Our ref: NO/2013/105409/01-L01
Your ref: 3/2013/0568
Date: 07 August 2013

**PROPOSED ERECTION OF A NEW DWELLING
LAND ADJACENT TO 10 WHALLEY ROAD, MELLOR BROOK**

title	Site Layout & Sections
-------	------------------------

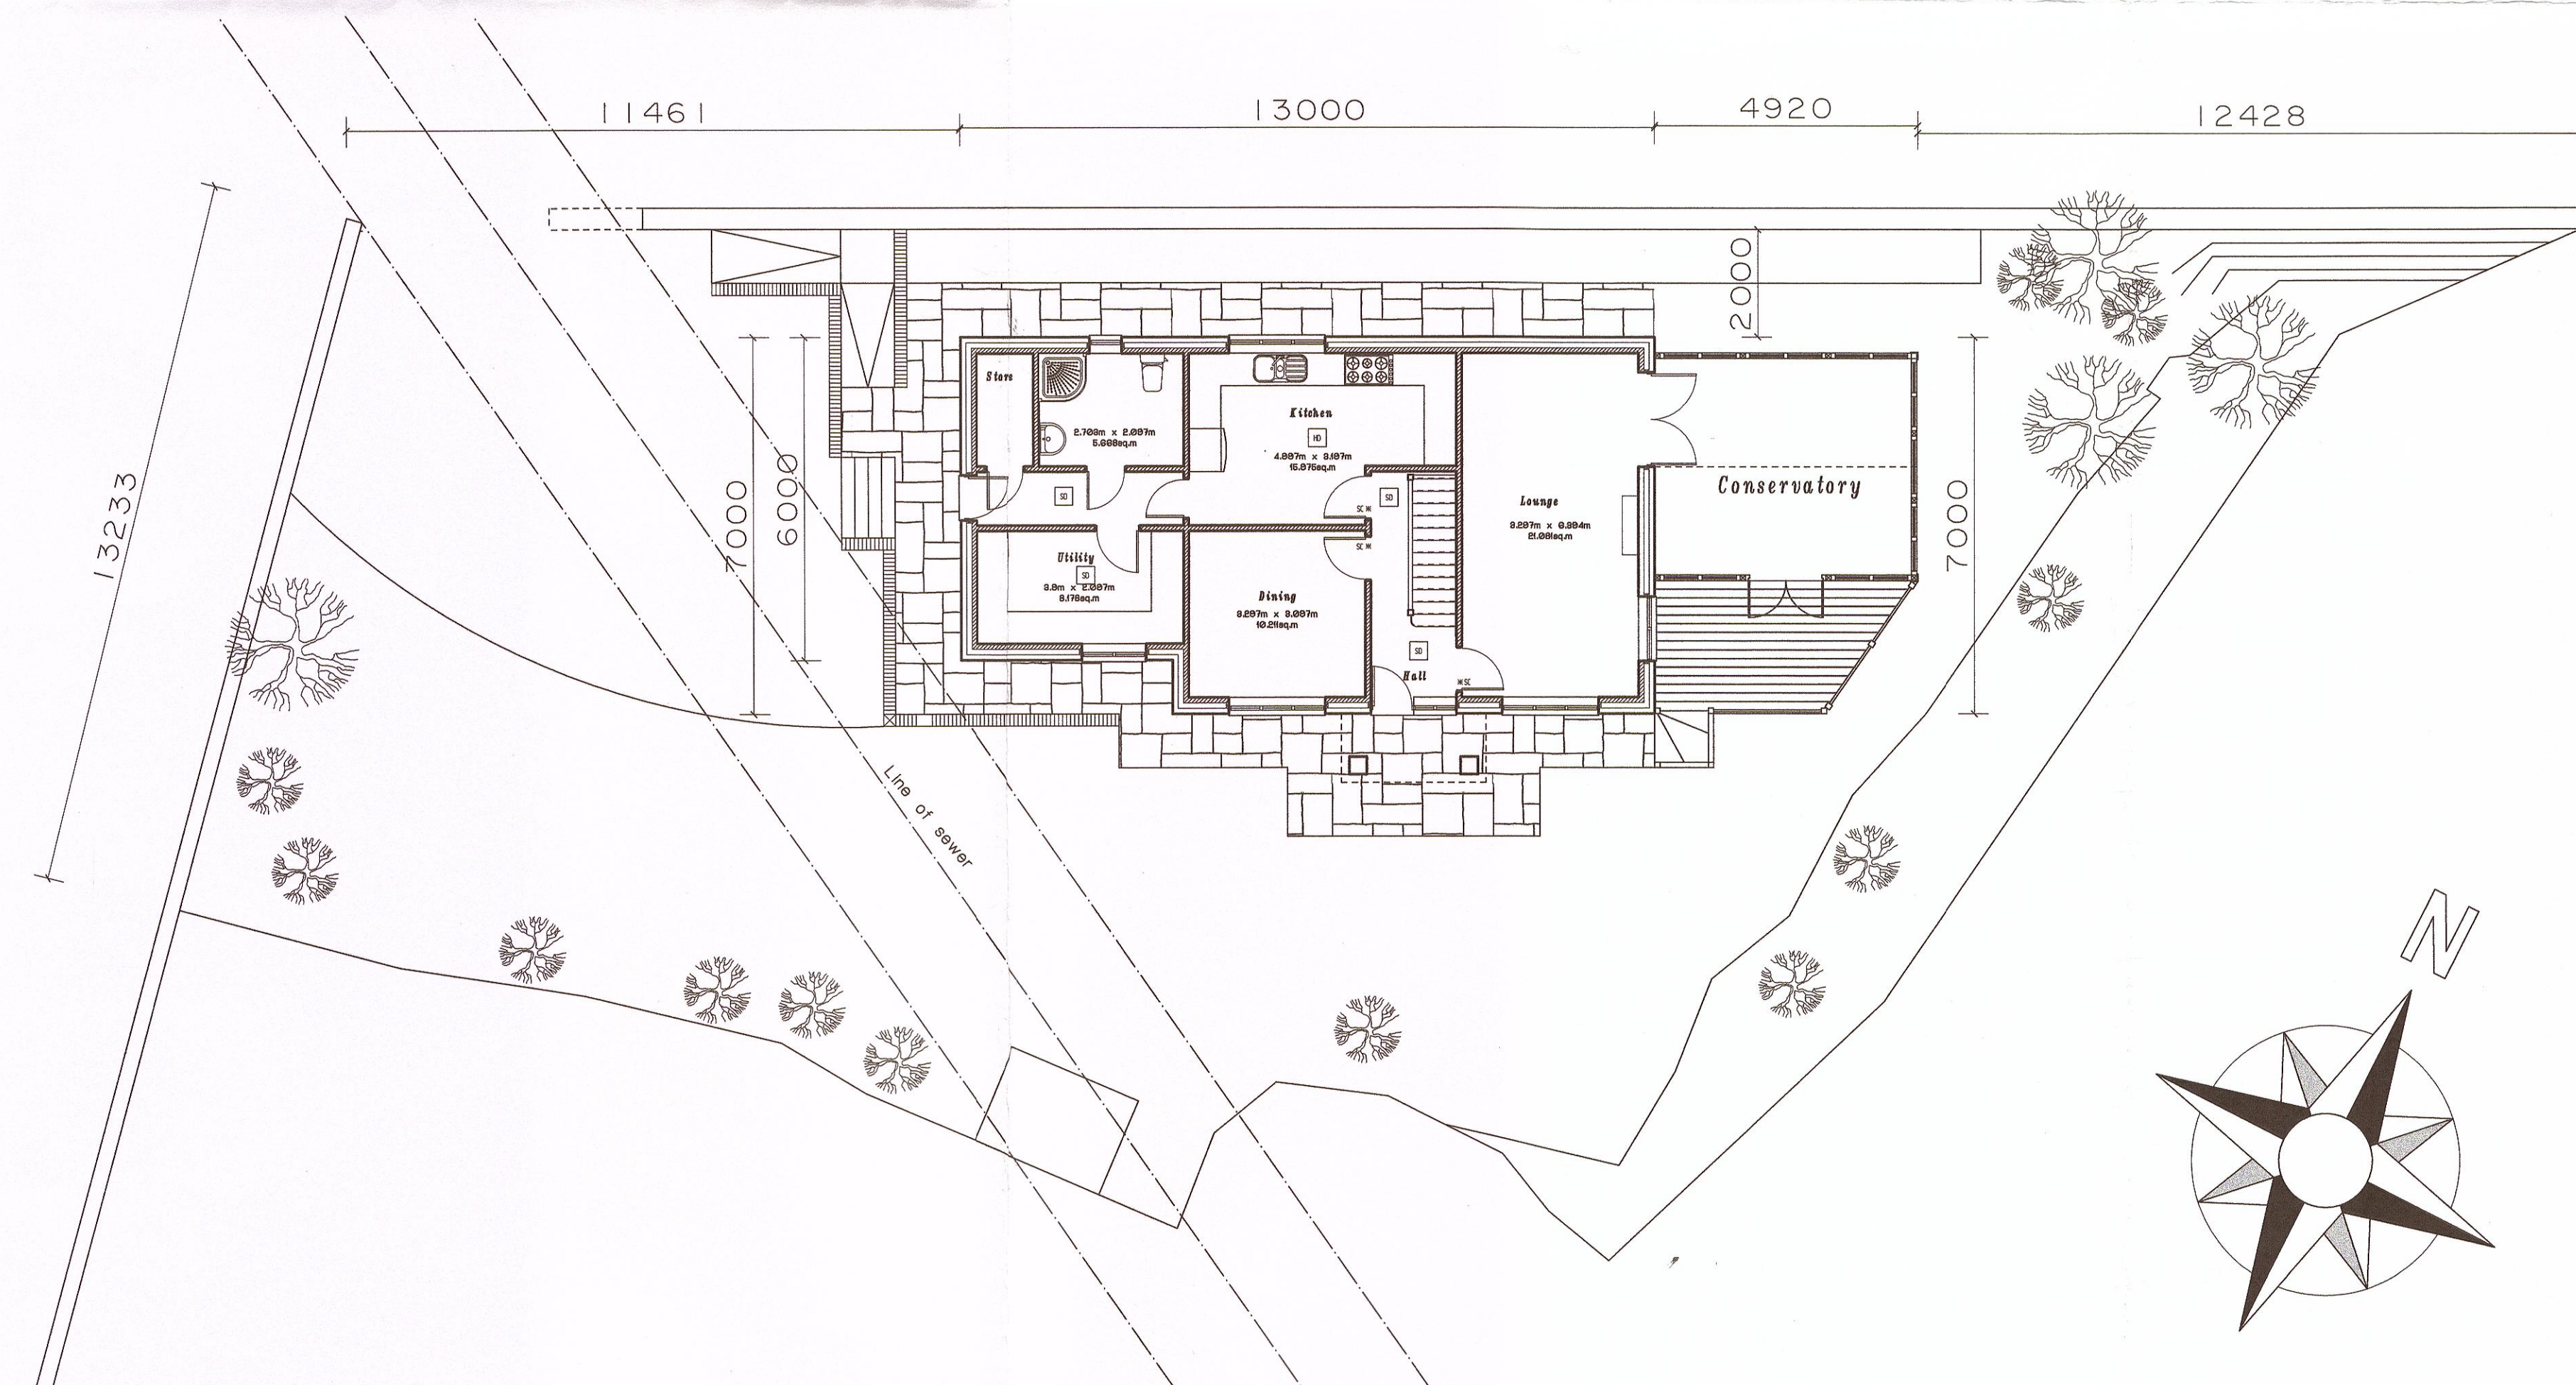
The proposed development is adjacent to Mellor Brook. We have no records of species or protected habitats near this site, but the developer should still seek to ensure that the habitat and amenity value of the watercourse is not permanently destroyed as a result of the development.

CONDITION No development shall take place until a scheme for the boundary treatment adjacent to the watercourse has been submitted to and approved in writing by the Local Planning Authority. Such a scheme shall be completed in accordance with the approved plans.

It is proposed to discharge surface water to the adjacent watercourse, Mellor Brook. Surface water run-off should be controlled as near to its source as possible through a sustainable drainage approach to surface water management (SUDS). SUDS are an approach to managing surface water run-off which seeks to mimic natural drainage systems and retain water on or near the site as opposed to traditional drainage approaches which involve piping water off site as quickly as possible. SUDS involve a range of techniques including soakaways, infiltration trenches, permeable pavements, grassed swales, green roofs, ponds and wetlands. SUDS offer significant advantages over conventional piped drainage systems in reducing flood risk by attenuating the rate and quantity of surface water run-off from a site, promoting groundwater recharge absorbing diffuse pollutants and improving water quality. Ponds, reedbeds and seasonally flooded grasslands can be particularly attractive features
